Applicant Response to GLA (Air Quality)

Planning Application Reference 2382/APP/2023/2906
Broadwater Lake, Moorhall Road, Harefield, UB9 6PE

Figure 3.6: Site wide parking arrangements

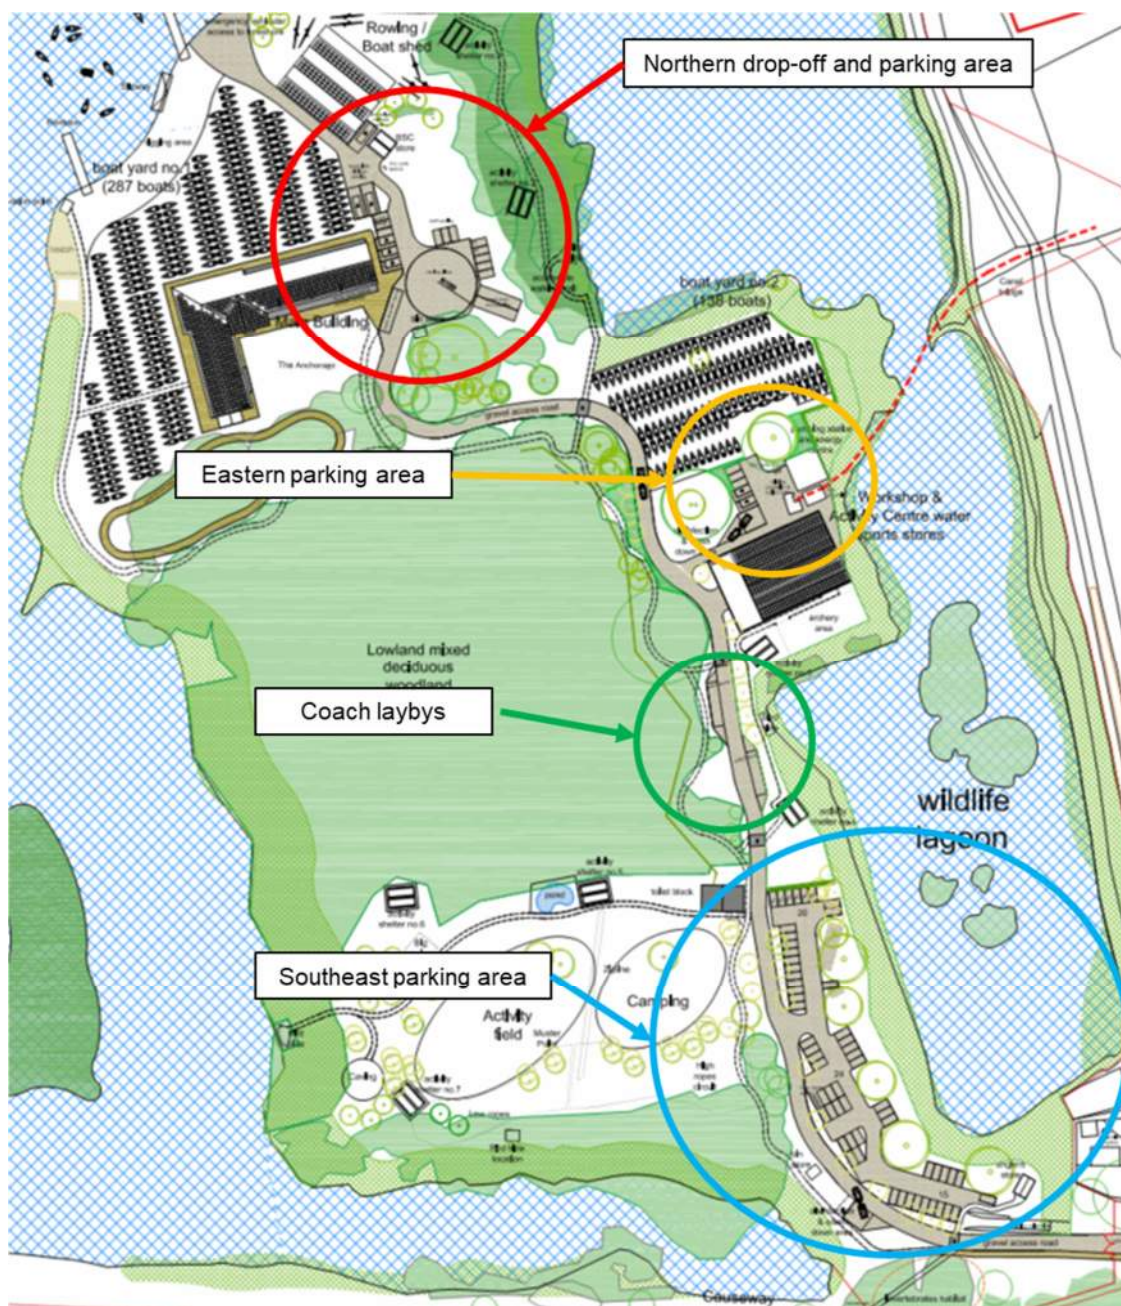
<p>The number of parking spaces must not exceed that accounted for in the submitted air quality neutral calculation</p>	<p>The Air Quality Neutral Calculation has been based on the car parking figures set out in the Transport Assessment, prepared by Robert West. The Transport Assessment confirms that 56 car parking spaces are proposed, of which 42 are standard parking bays, six are disabled parking bays and six and electric vehicle parking bays.</p>

<p>Planning Condition No. 36 as currently drafted requires the submission of a Landscape Scheme to the Local Planning Authority for approval, prior to the commencement of works above ground level. Criterion 2(e) requires the submission of a final car parking layout, including 56 car parking spaces, of which of which 42 are standard parking bays, six are disabled parking bays and six and electric vehicle parking bays. The condition also requires compliance with the details, once approved.</p>
--	--
